**CITY OF MERCER ISLAND**

August 29, 2017

RE: ADU17-003, CAO17-005, SHL17-007, SUB17-004 Second Review Letter  
Land Use Applications for proposed home, ADU, driveway and retaining wall construction within  
a steep slope along the shoreline for the Lady Bug Trust. DEV17-009 Impervious Surface  
Deviation Application has been withdrawn.

- ADU shall be consistent with the roof pitch, siding, and windows of the proposed main house.

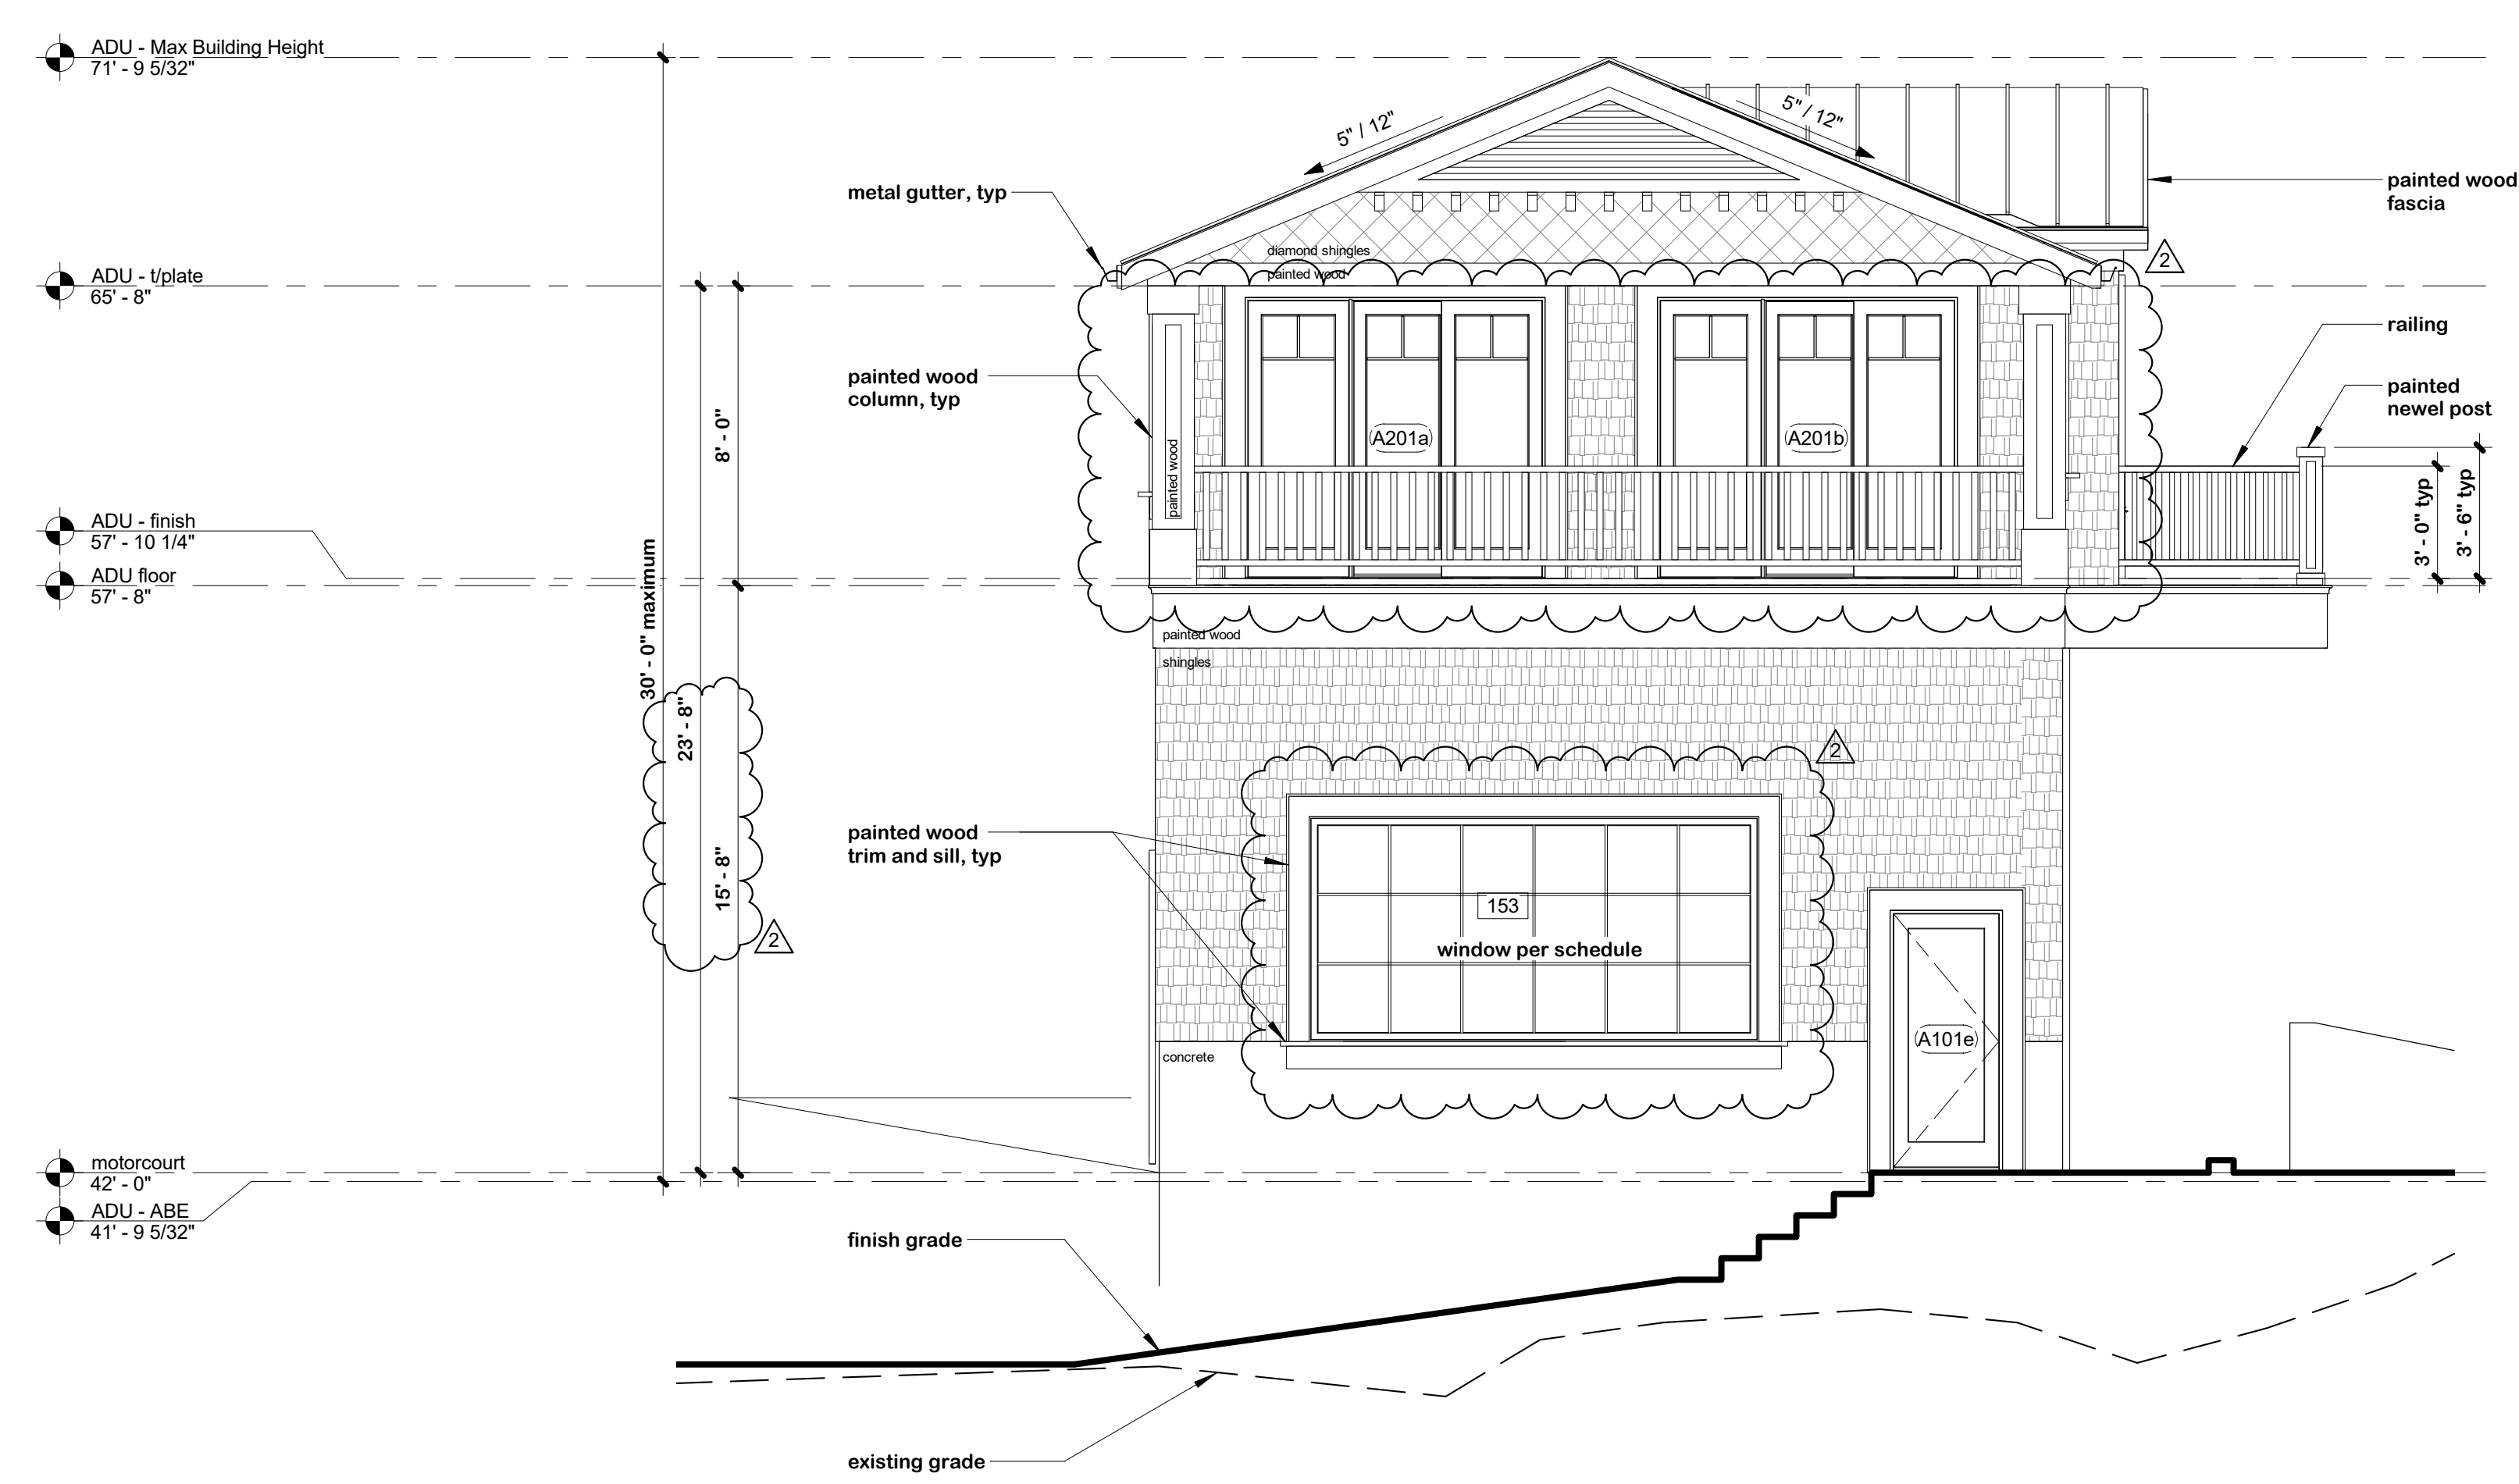
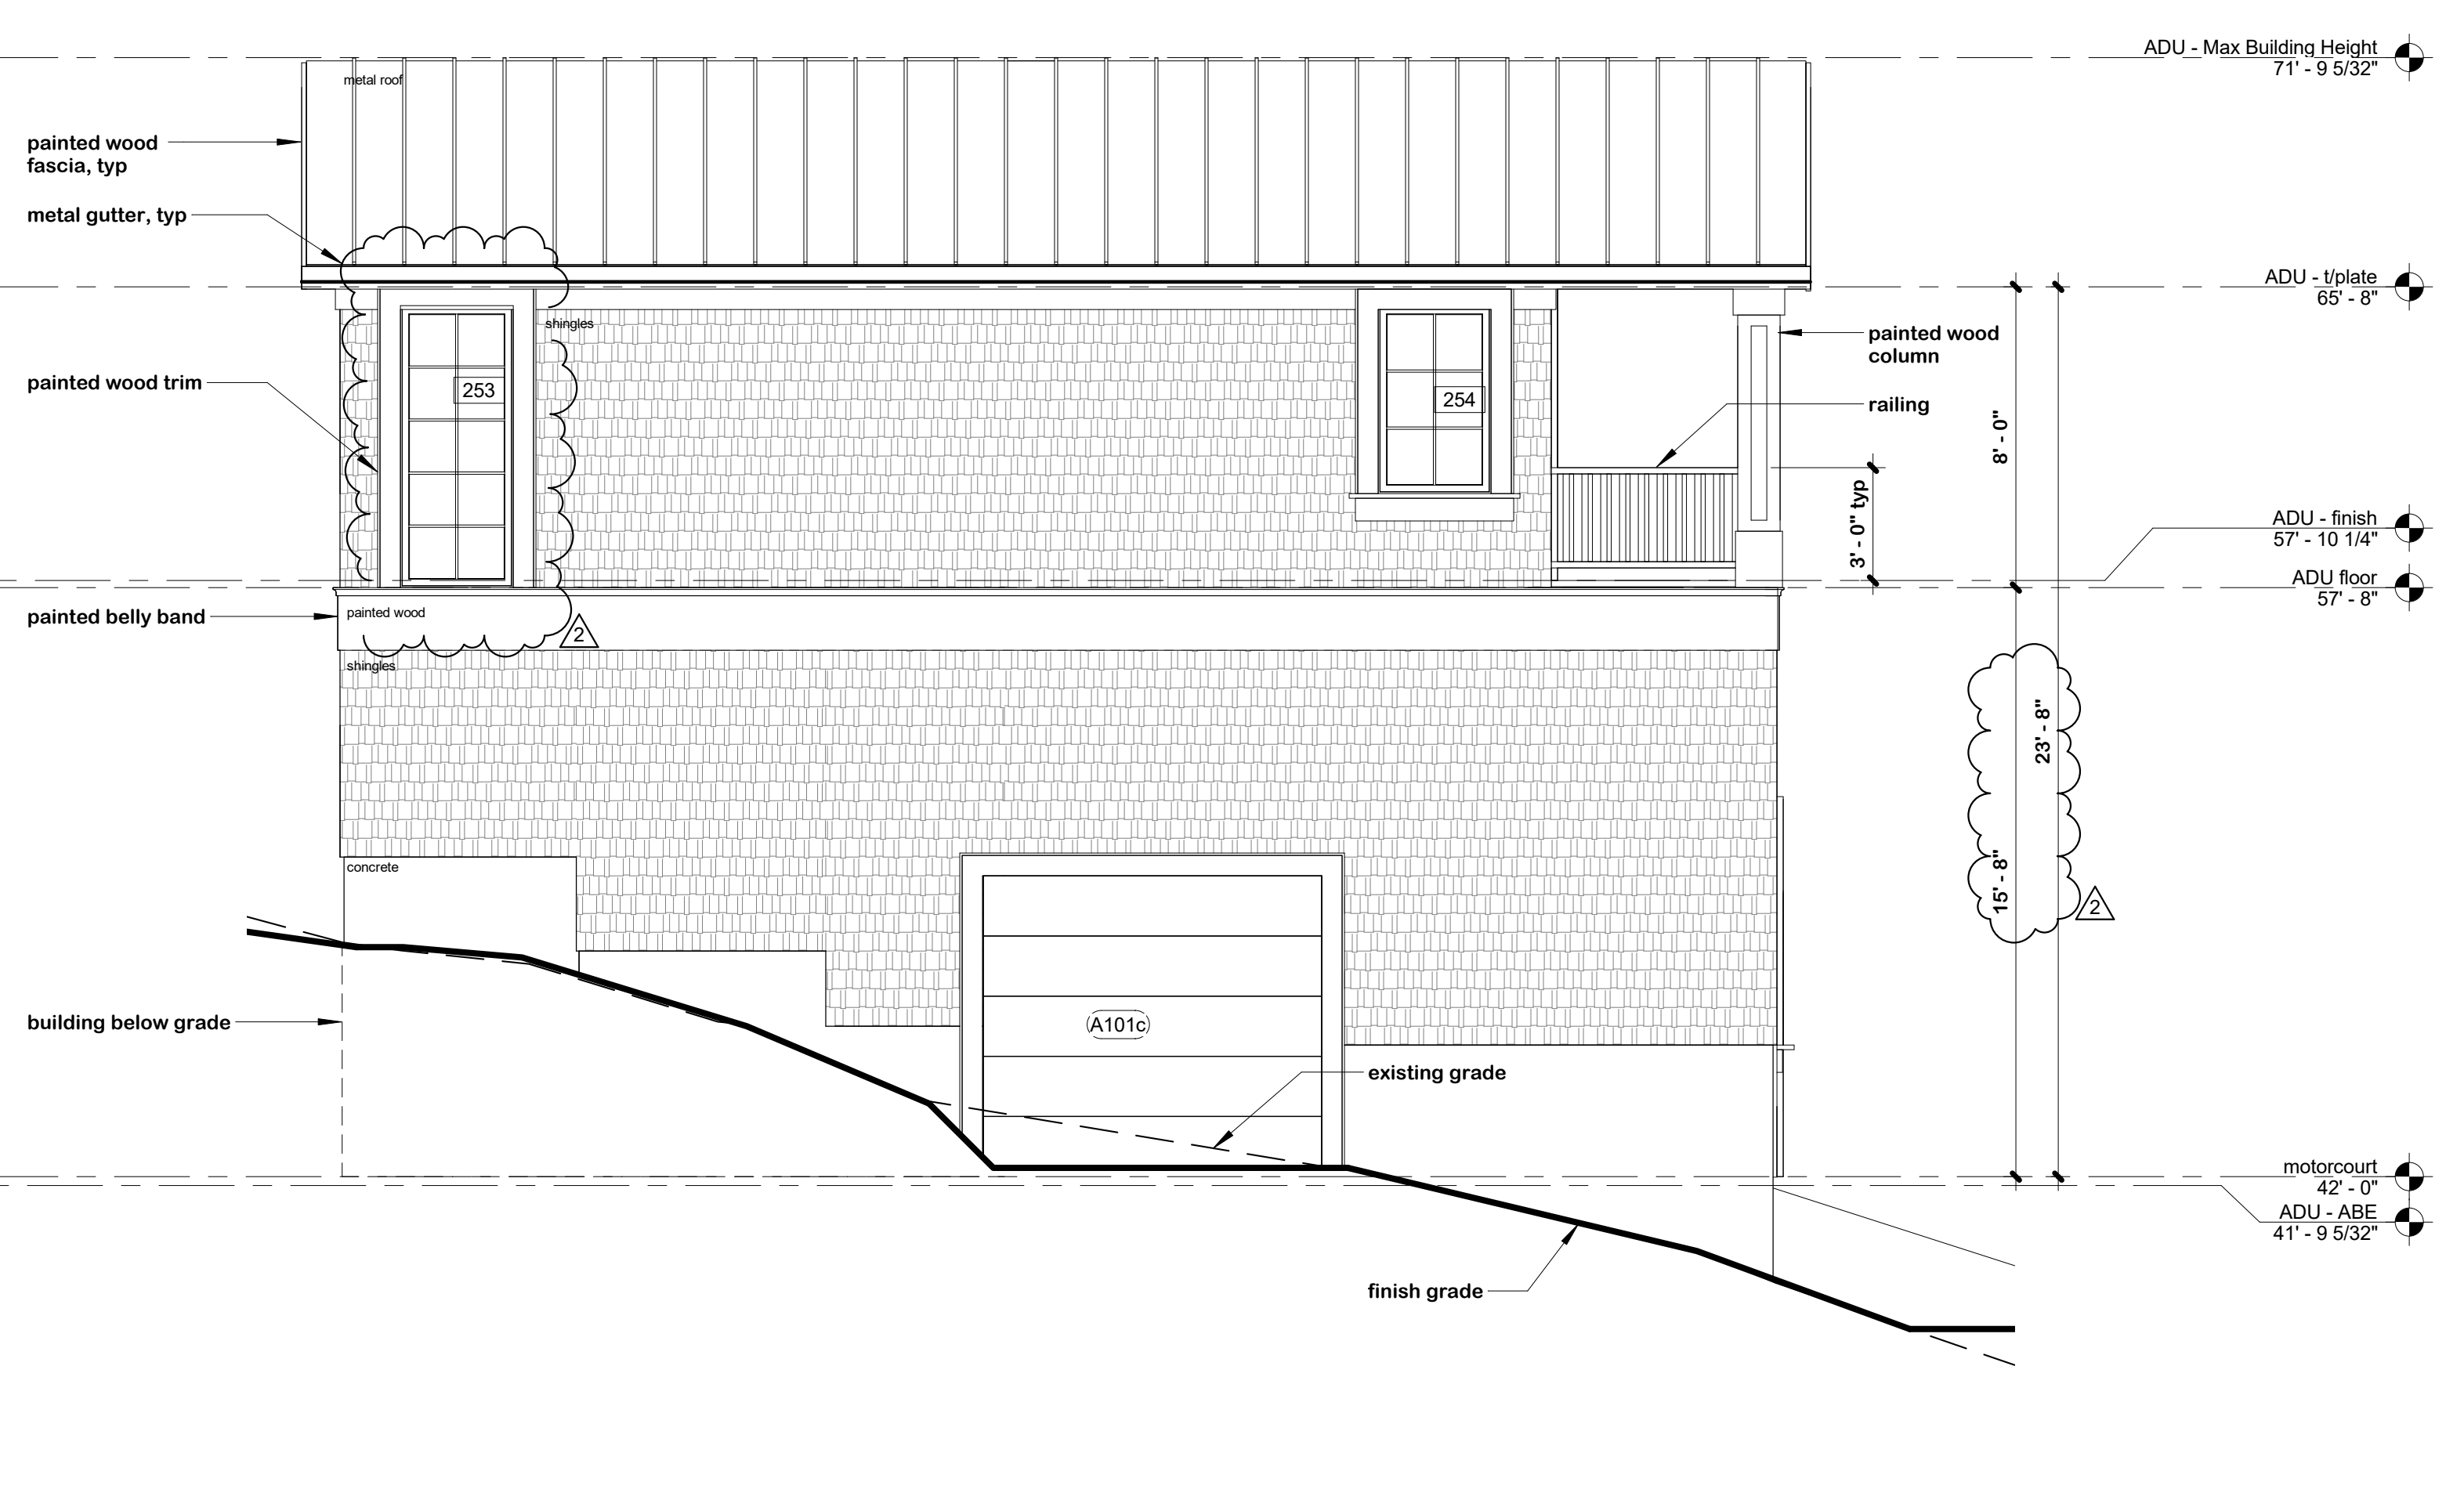
8. Please provide building elevation drawings that the ADU shall be designed consistent with the existing roof pitch, siding, and windows of the principal dwelling unit.
